Morrill's Crossing

33 Allen Avenue

To: Chair Delogu and Members of the Portland Planning Board
From: Sarah Hopkins, Development Review Services Manager
Date: July 15, 2004
Re: Planning Board Workshop July 20, 2004
Packard Proposed Conditional Rezoning

The following summarizes my comments as it relates to a review of the June 18, 2004 Traffic Impact and Access Study and supporting material prepared by Vanasse Hangen Brustlin, Inc.

## Exhibit B Site Plan Exhibit

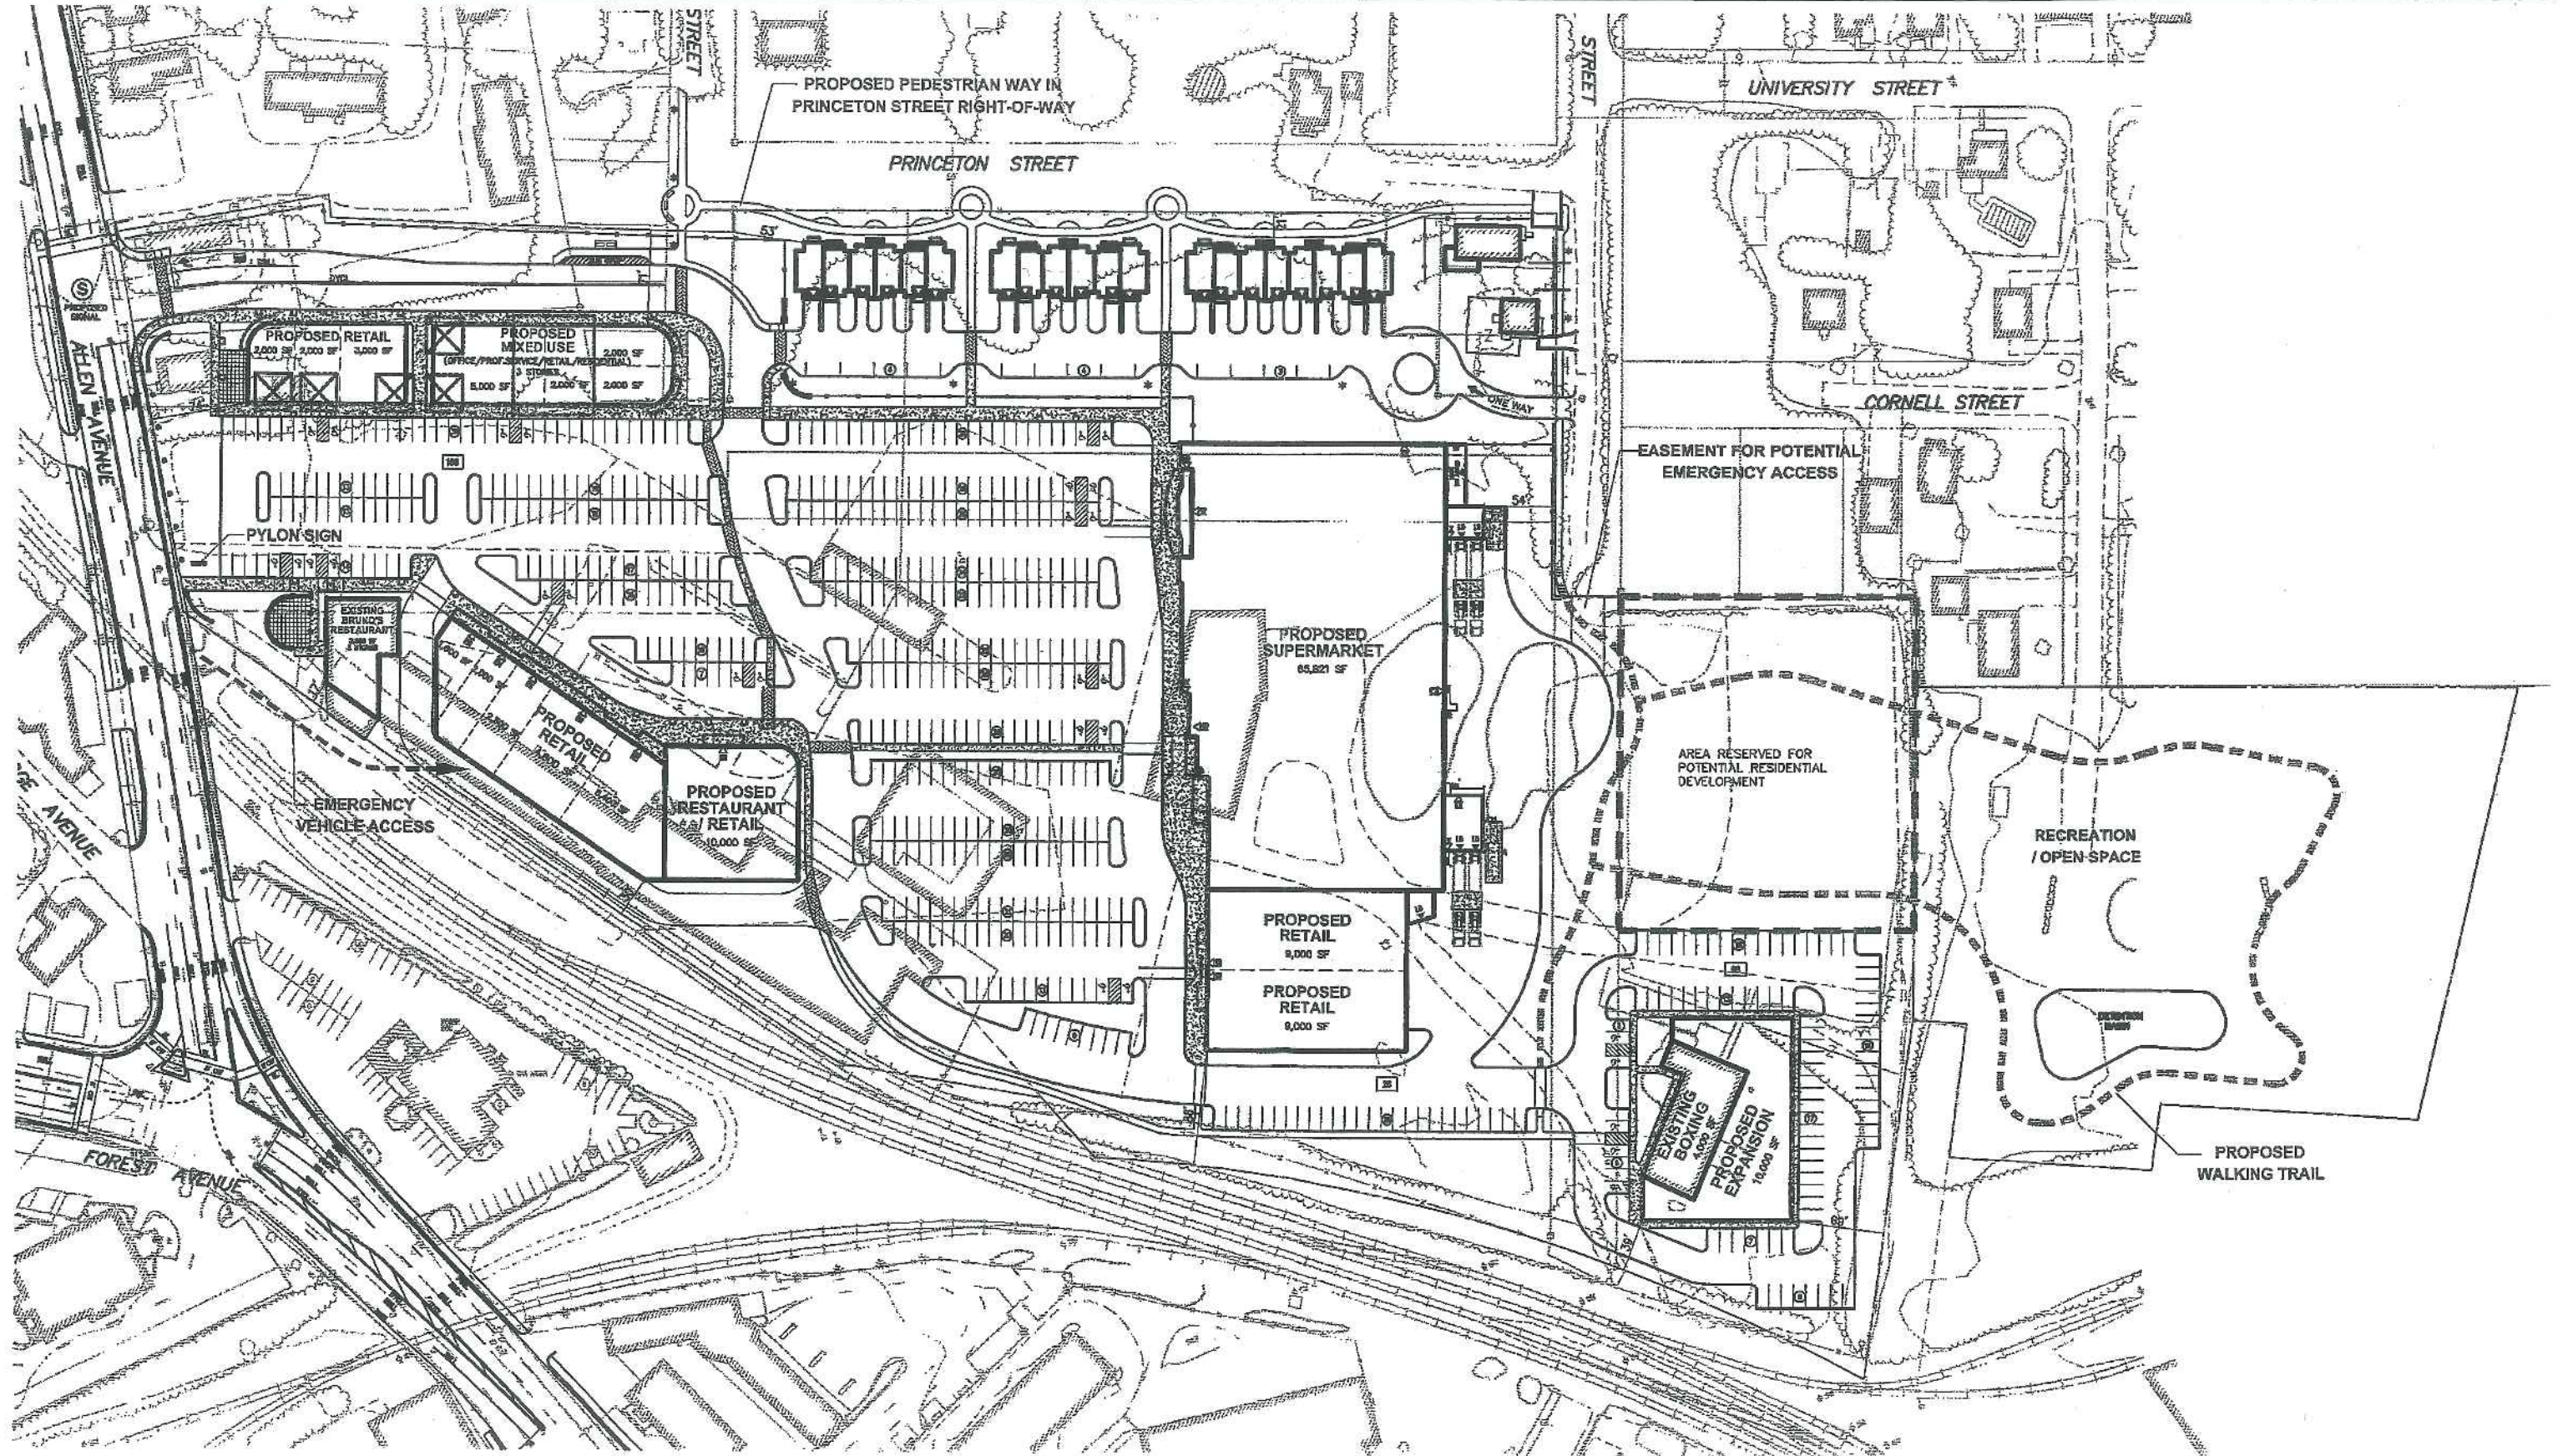
- 2.. The applicant should conduct and present a traffic simulation of the Morrill's Corner area.
- 3.. Access management issues adjacent to the Allen Avenue/Site Drive intersection need resolution. It is suggested that Paul White Tile driveways be reconfigured to align opposite the site driveway and be controlled by the proposed traffic signal. Additionally, the driveway to the apartment complex easterly of the site should be closed.

- 5.. Access to the abutting neighborhood should be provided such that local traffic can directly access the proposed development without having to turn onto Allen Avenue. This connection will provide the benefit of access to the proposed traffic signal, thus providing neighbors the opportunity to utilize those benefits during peak traffic time periods when left-turns from side streets is difficult.

- 8.. The lane assignment at the proposed site drive should be revised. The westbound Allen Avenue approach should consist of an exclusive left-turn lane and one through lane. The eastbound Allen Avenue approach should consist of one or two through lanes and one right-turn lane. Additionally, the eastbound

lane merge should be lengthened for a distance of at least twelve times the green time at the intersection (engineering approximation). A revised level of service analysis should be performed to ensure that this lane arrangement would operate reasonably.

## Exhibit C Off-Site Improvements

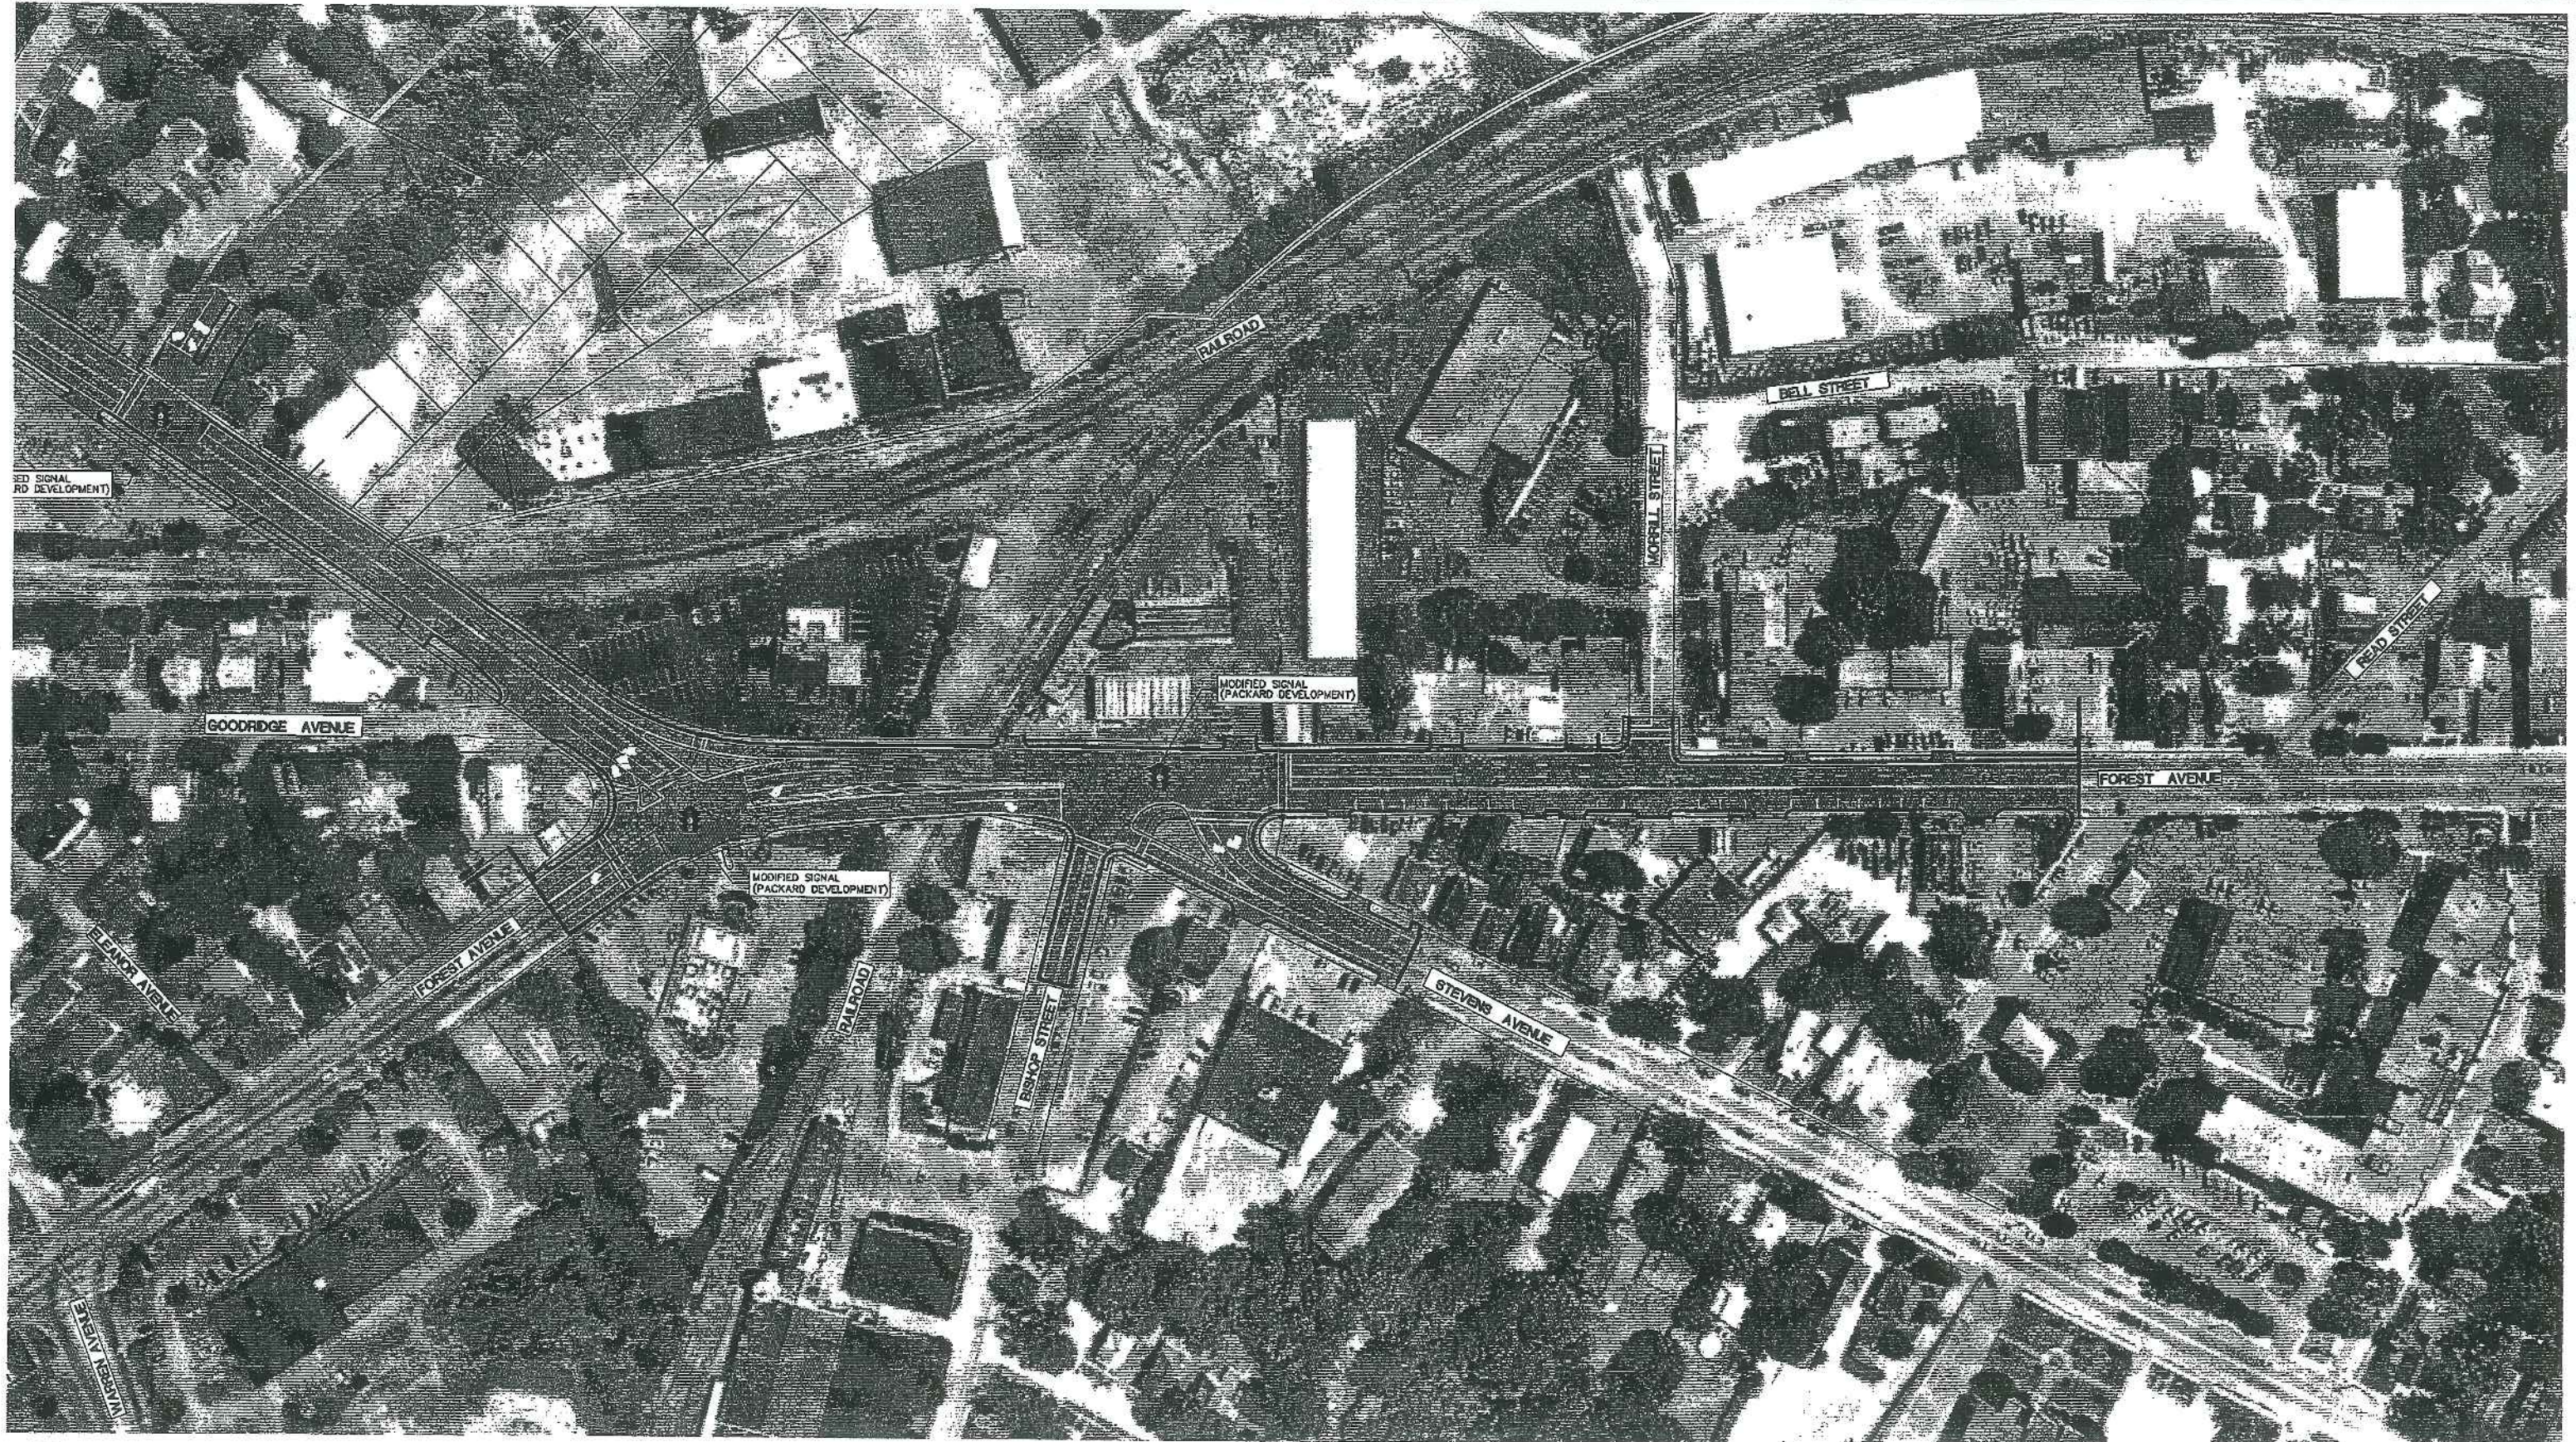
- 1.. A detailed improvement plan has been provided for Forest Avenue from Allen's Corner to Bell Street. A similar plan should be provided along Allen Avenue from Forest Avenue to a point east of the project site drive where roadway changes end. I would also ask that the Forest Avenue plan illustrate how the four-lane section will match with the existing two-lane section south of Bell Street.

9.. The applicant should consider the provision of a crosswalk across Forest Avenue from the McDonald's Restaurant to the channelization island separating flow to Allen Avenue eastbound.

m.. The intersection of Forest Avenue and Bell Street should be evaluated assuming traffic signalization and roadway conditions as depicted on the conceptual improvement plan.

p.. Specific details on the recommended improvements to pedestrian facilities (sidewalks, crosswalks, etc.) should be provided.
